Project Name: NORTH ALBUQUERQUE ACRES UNIT A

LYLE J HOFFERTH agent(s) for GRACE CHURCH request(s) the above action(s) for all or a portion of Lot(s) CDS-1A, Block(s) 20, **NORTH ALBUQUERQUE ACRES Unit(s) A**, zoned C-1, located on SAN ANTONIO NE BETWEEN LOUISIANA NE SAN PEDRO NE containing approximately 8.1 acre(s). (D-18) [*Deferred from 8/6/08 & 8/13/08*] **THE SITE DEVELOPMENT PLAN FOR BUILDING PERMIT WAS APPROVED WITH FINAL SIGN-OFF DELEGATED TO CITY ENGINEER FOR SIA AND FOR APPROVAL FROM SOLID WASTE. 3 COPIES OF THE APPROVED SITE PLAN MUST BE PROVIDED TO PLANNING.**

**RE:** Project # 1001904 (Site development plan for building permit)

7. **Project #1001904**  
**Application # 02DRB-00626**  
**Grace Church**

**J1** NORTHEAST ELEVATION

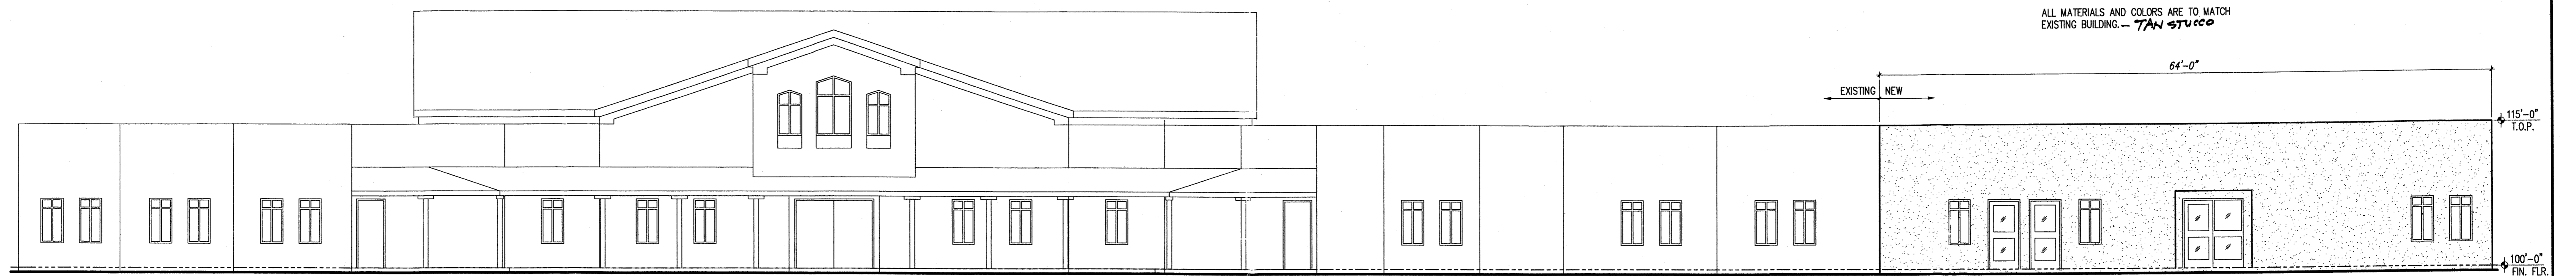
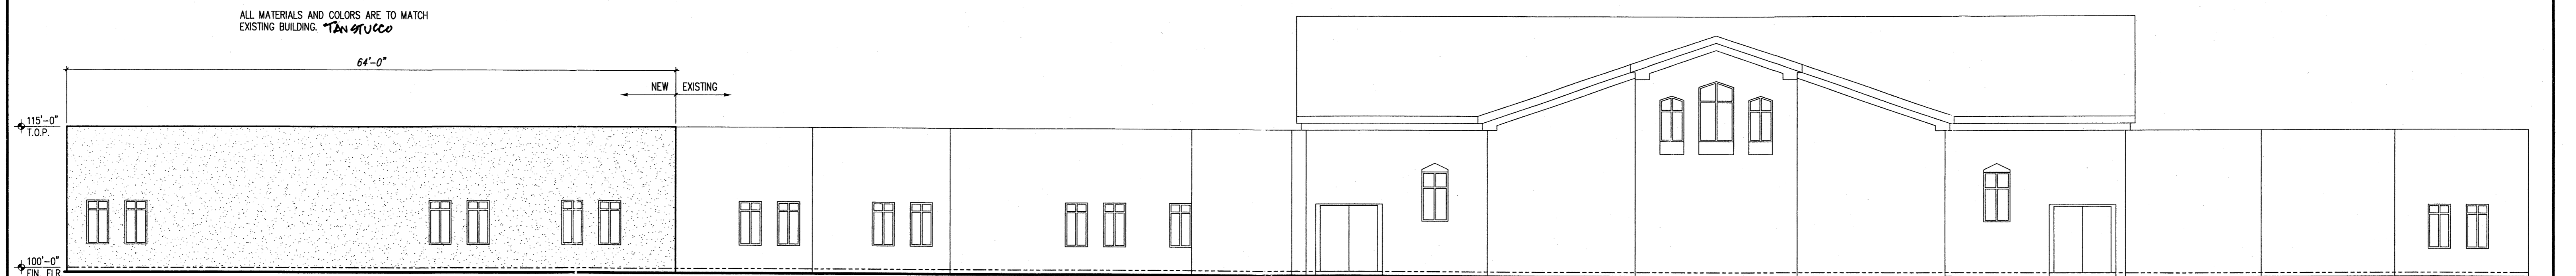
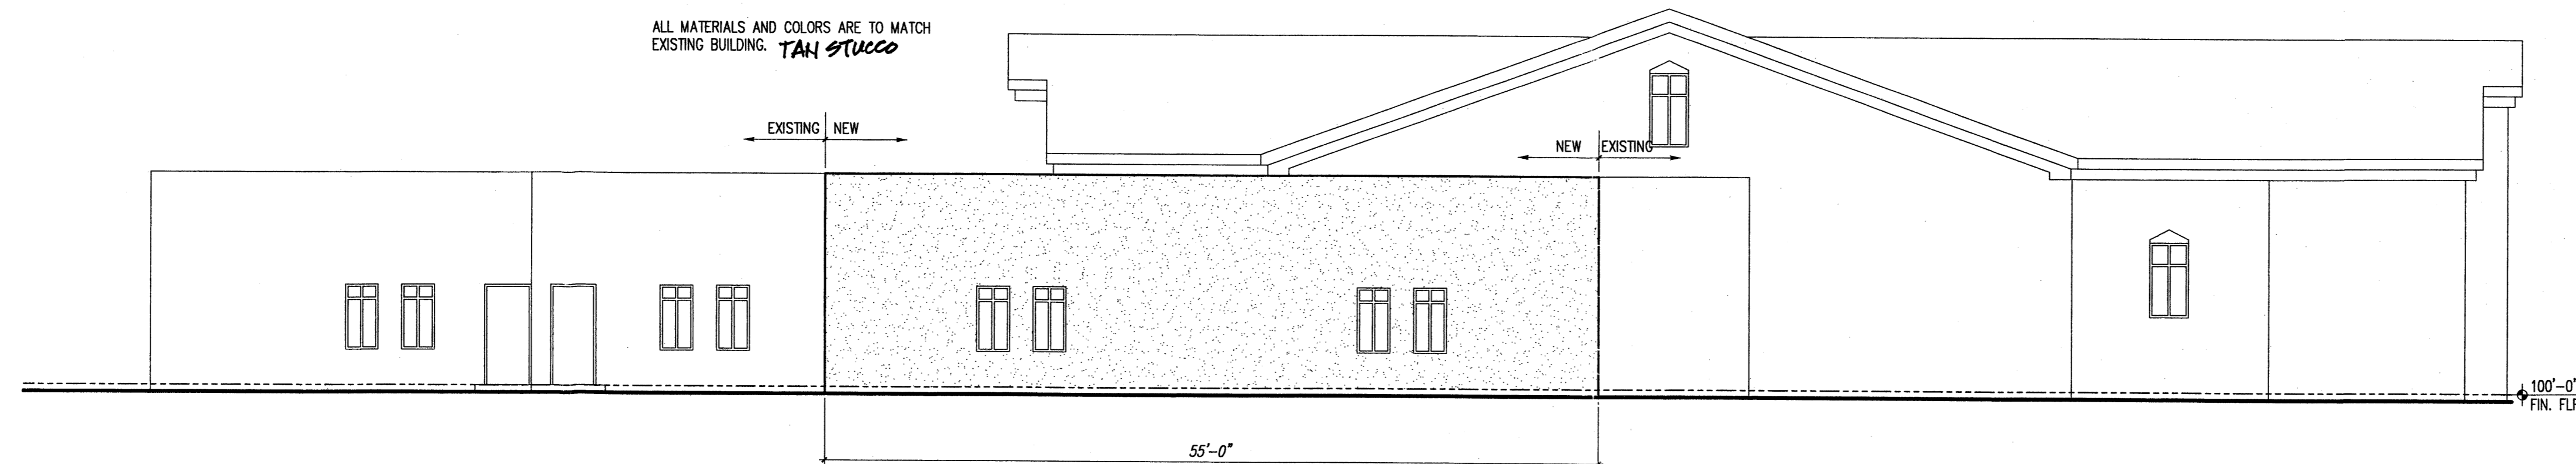
1. Please call out the colors on the elevations.
2. Specify the type of material used in the dumpster enclosure and color/s. Also, an opaque gate needs to be added to the detail.
3. The landscape plan indicates that "1 new tree required for 91 parking spaces". Please clarify/correct.
4. No objection to delaying the ten foot buffer landscaping to the next construction phase.
